**From:** Mark Peacock  
**Sent:** 24 November 2016 11:40  
**To:** Planning  
**Subject:** FW: Northaw; The Oshwal centre, Coopers Lane Road 16/ 1067/FUL

**From:** Andrew Robley  
**Sent:** 04 November 2016 14:22  
**To:** Mark Peacock  
**Subject:** Northaw; The Oshwal centre, Coopers Lane Road 16/ 1067/FUL

EXISTING AND PROPOSED FRONTS
AND SECTIONS

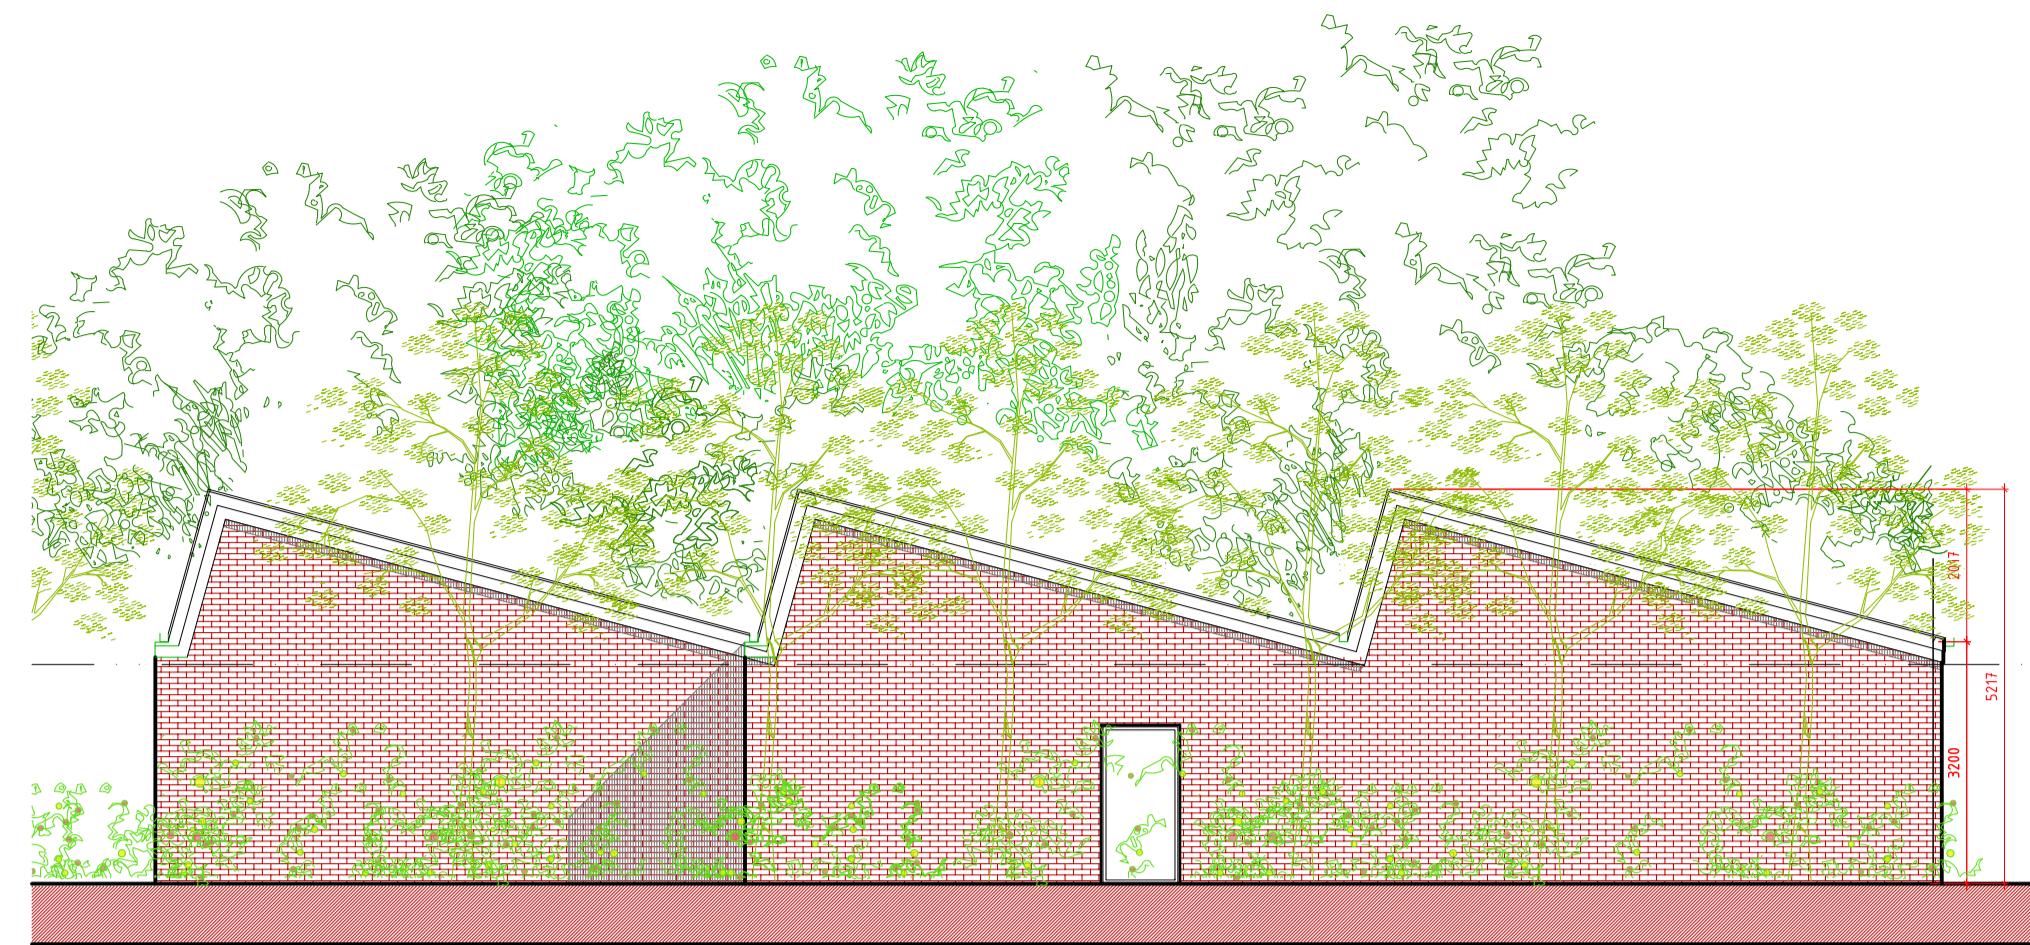
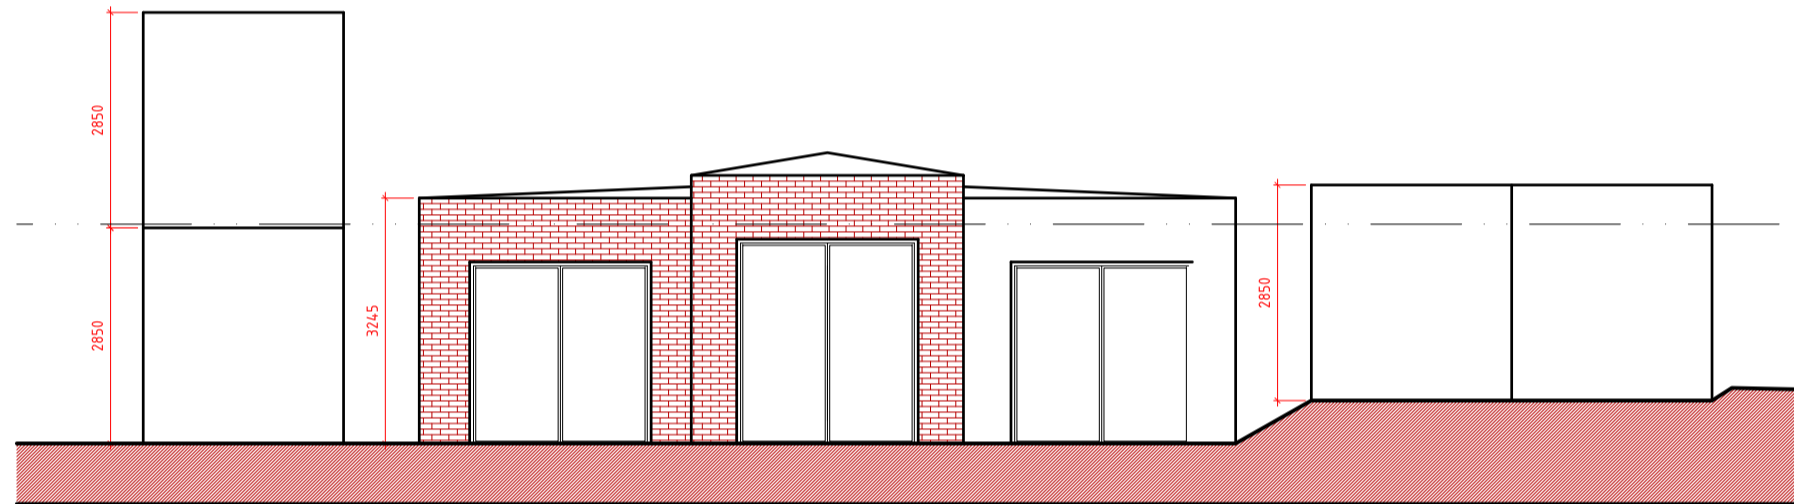
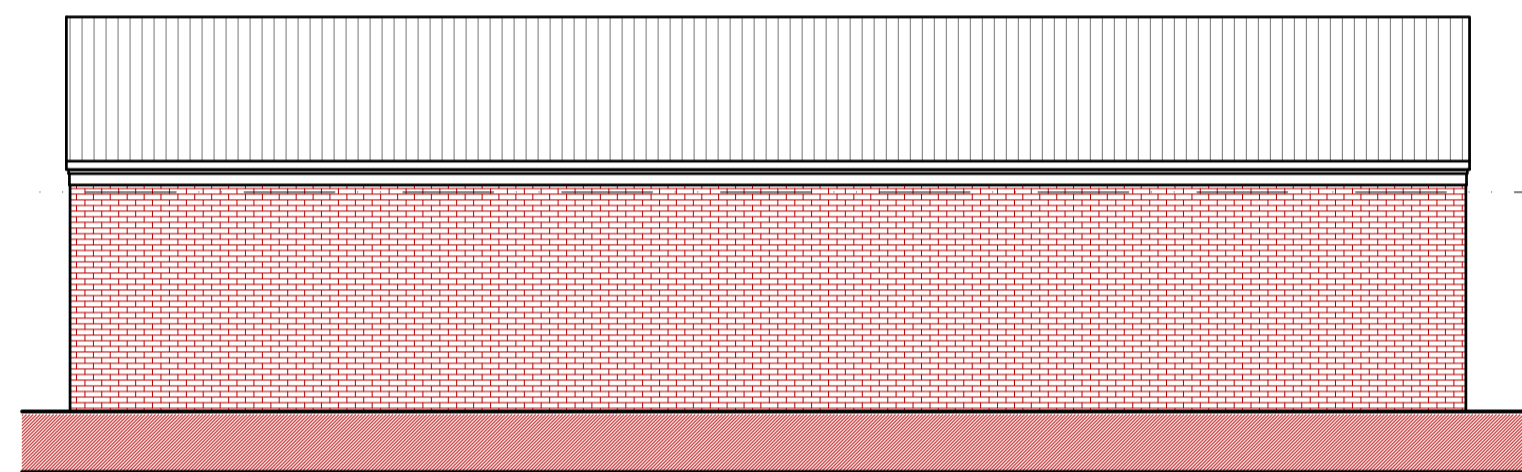
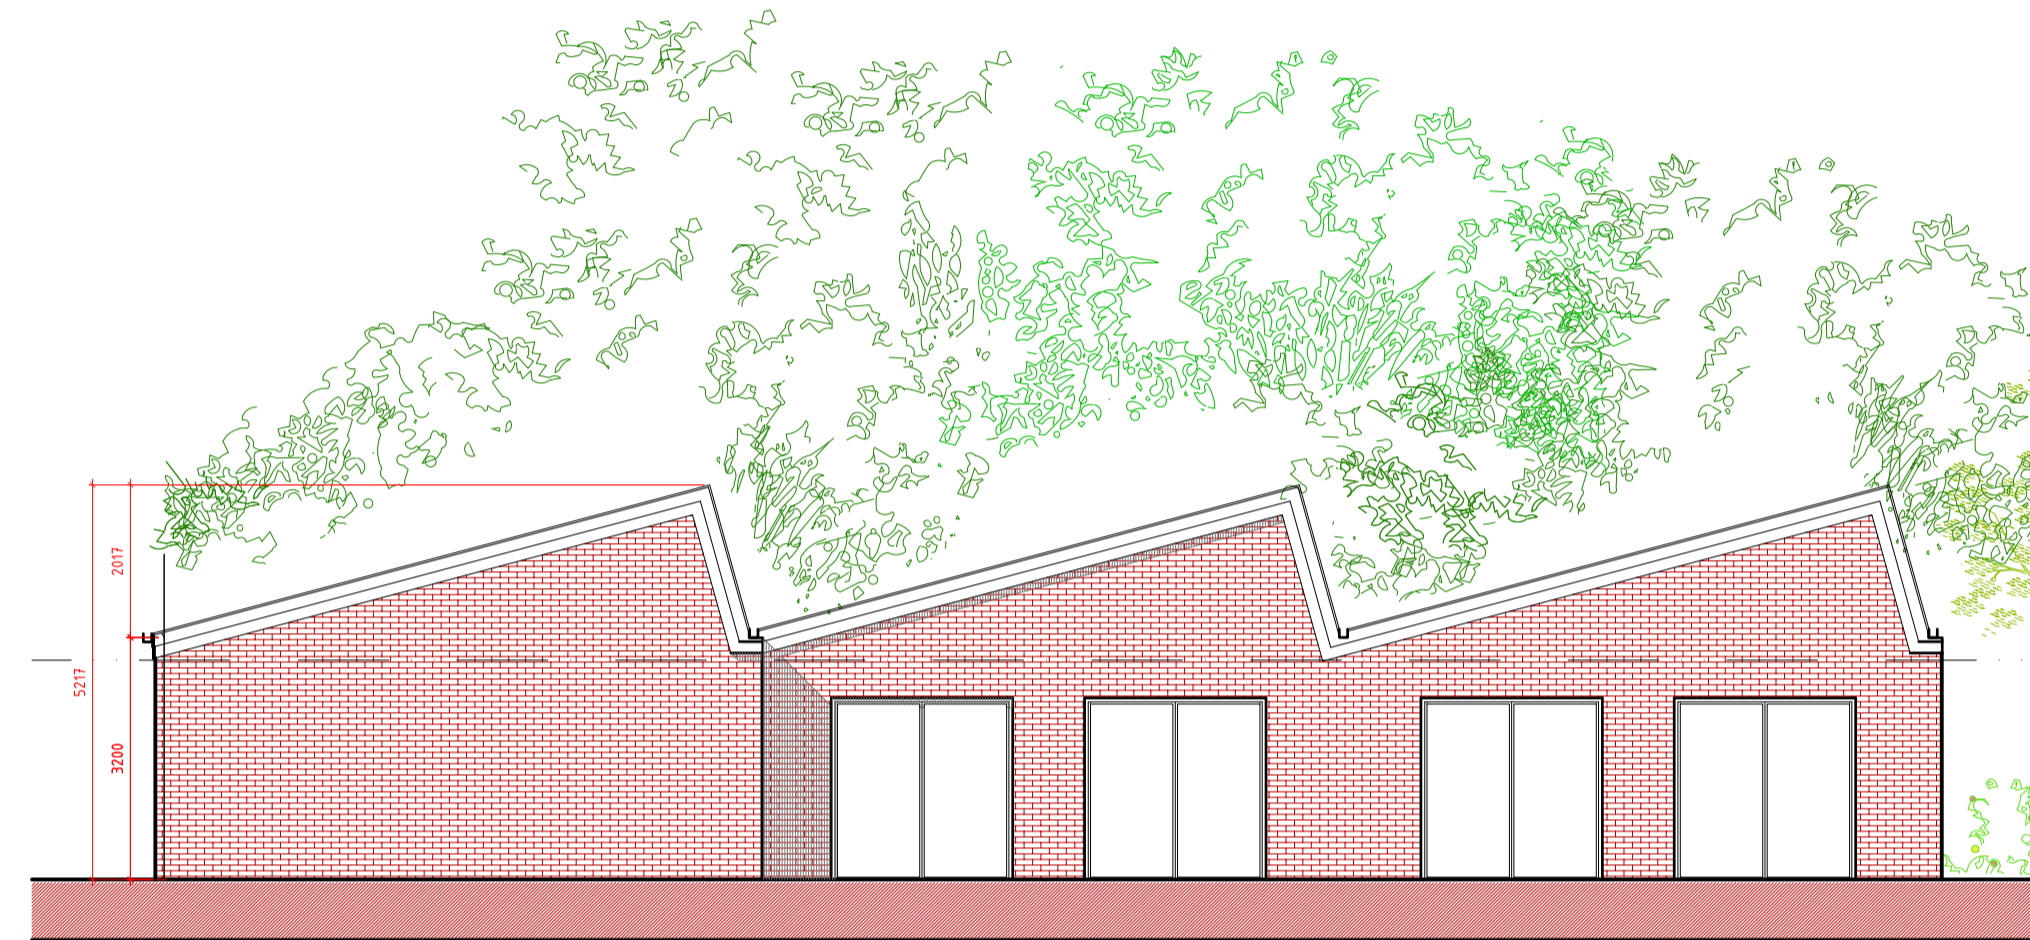
**The proposal** is to replace this facility with a somewhat larger building and higher in respect of overall roof height which would be approximately 5M. This is because the roof is similar to a C20th factory building in "saw tooth" form with "north lights". According to the Planning Statement, this is to give extra height for storage and to provide natural day-lighting without low level windows ( for security).

Whilst the current shipping containers should not set a precedent for the amount of building, in my view a building of this area and in this location would in principle not necessarily, significantly harm the setting of the listed building, However, the overall amount of building in this corner is becoming an issue and therefore it should be made as in conspicuous as possible. The additional height is therefore an issue and the "saw tooth" roof draws attention to this. Whilst the building is set down into the landscape, it would be advantageous for the banking up of a grassed bund , which could also be planted with screening planting. In addition, the Architects should consider turning the roof form by 90 degrees so that the saw tooth form is facing away from the LB. it would also be advantageous to consider a "green roof" which would also blend the building into the landscape and avoid the appearance of standard profiled metal roofing which might otherwise be contemplated.

If these amendments were to be made, I would advise that the proposals would not significantly harm the setting of the LB and would conform to the NPPF 2012 , paras 7, 8, 9 , 131, 132, 134, PPG 2014, Historic England- "Conservation Principles" and Historic Environment Good Practice Advice in Planning Note 3 , Local Plan R22, R25, Emerging Core Strategy CS11; The Planning( listed buildings and conservation areas)Act 1990.

1. Prior to the commencement of any works on site, precise details of the following must be submitted to and approved in writing by, the Local Planning Authority;-a) the roof eaves , verges and glazing 1:5 details, b) new external doors – 1:20 elevations and 1:5 sectional details.
2. Materials Samples C.5.1
